**Development Review Board (DRB)
Review Comments
Utility Development Section
Reviewer: Jon Ertsgaard, P.E.
Phone: 505.289.3028**

DRB Project No: 1003445	Date: 05/09/2018	Item No: #1
Zone Atlas Page: C-12	Legal Description: Tract(s) G, FOUNTAIN HILLS PLAZA SUBD zoned SU-1 FOR PDA TO INCLUDE C-3 USES, Location: located on 4011 PASEO DEL NORTE NW	
Request For: 18DRB-70061 MAJOR – SITE PLAN for BUILDING PERMIT

C200

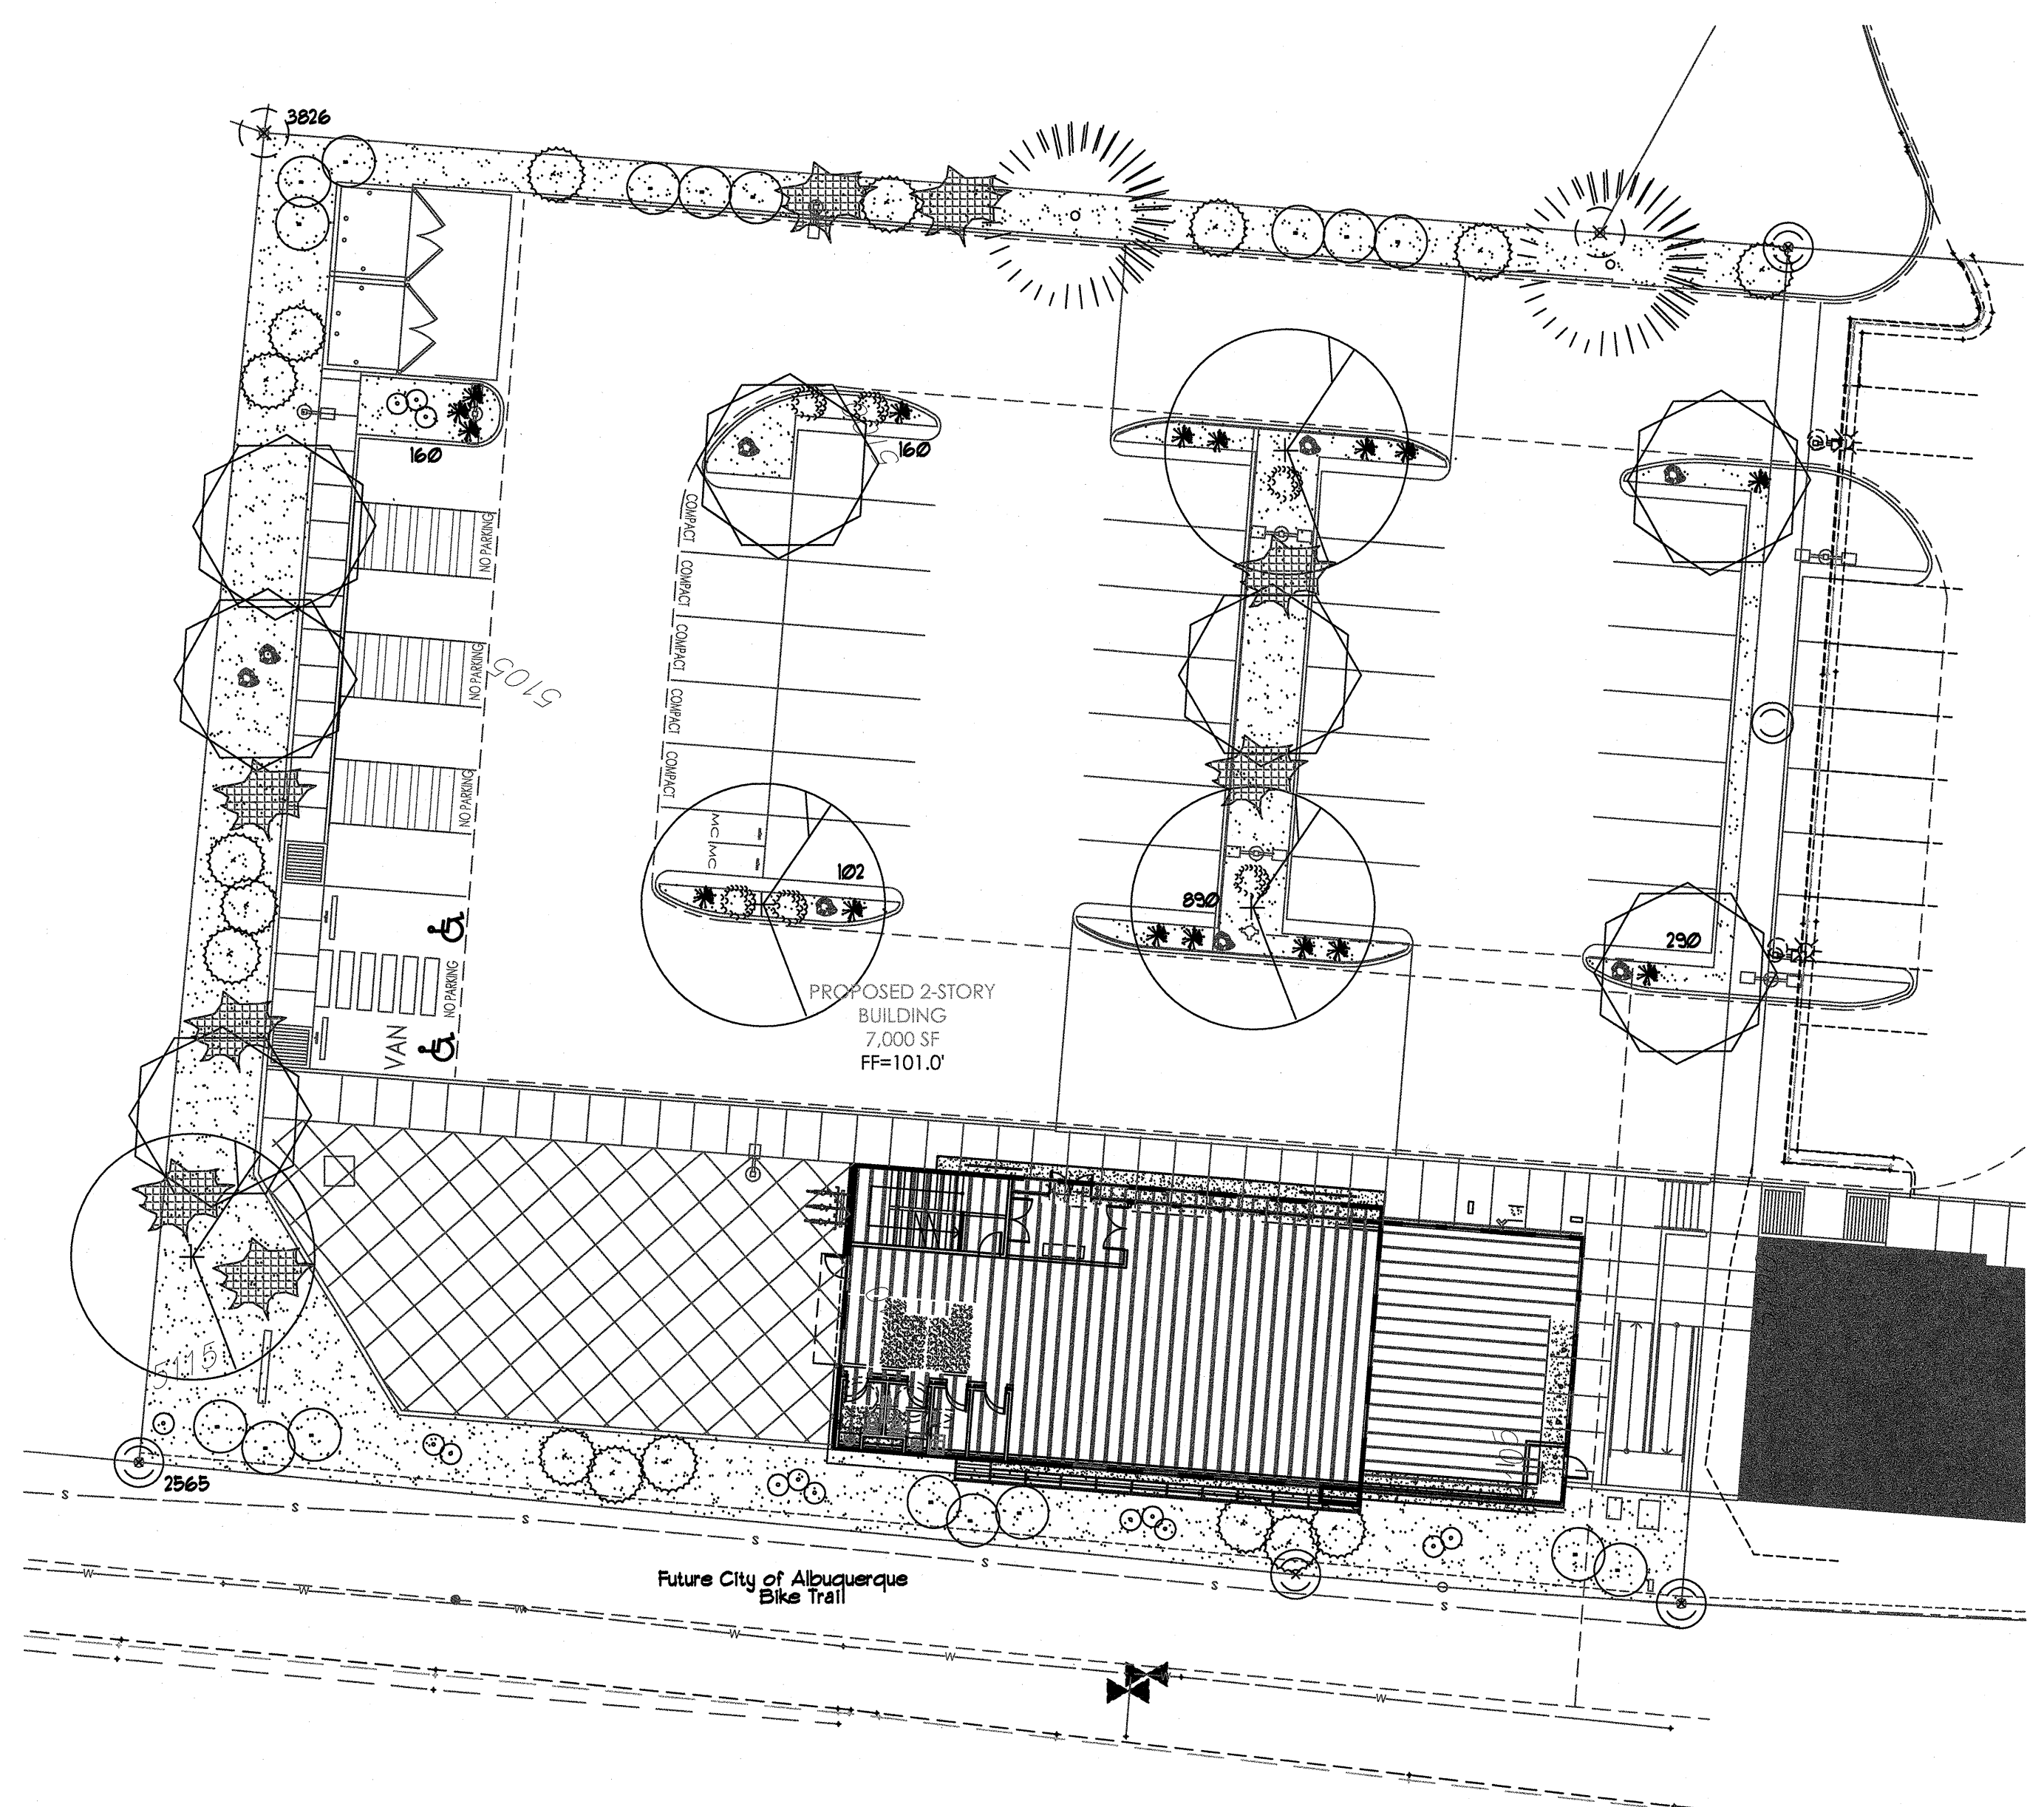
1. A water and sanitary sewer availability statement has been issued (#180208) and provides the requirements for water and sanitary sewer services.
2. The Utility Plan needs to be revised to show the water and sanitary sewer services and fire protection per the availability statement. Also, the Utility Plan needs to identify all on site private lines as such. An updated review submittal has not been received.
3. The subject property is outside of the WUA adopted service area and will require a board approved service connection agreement.
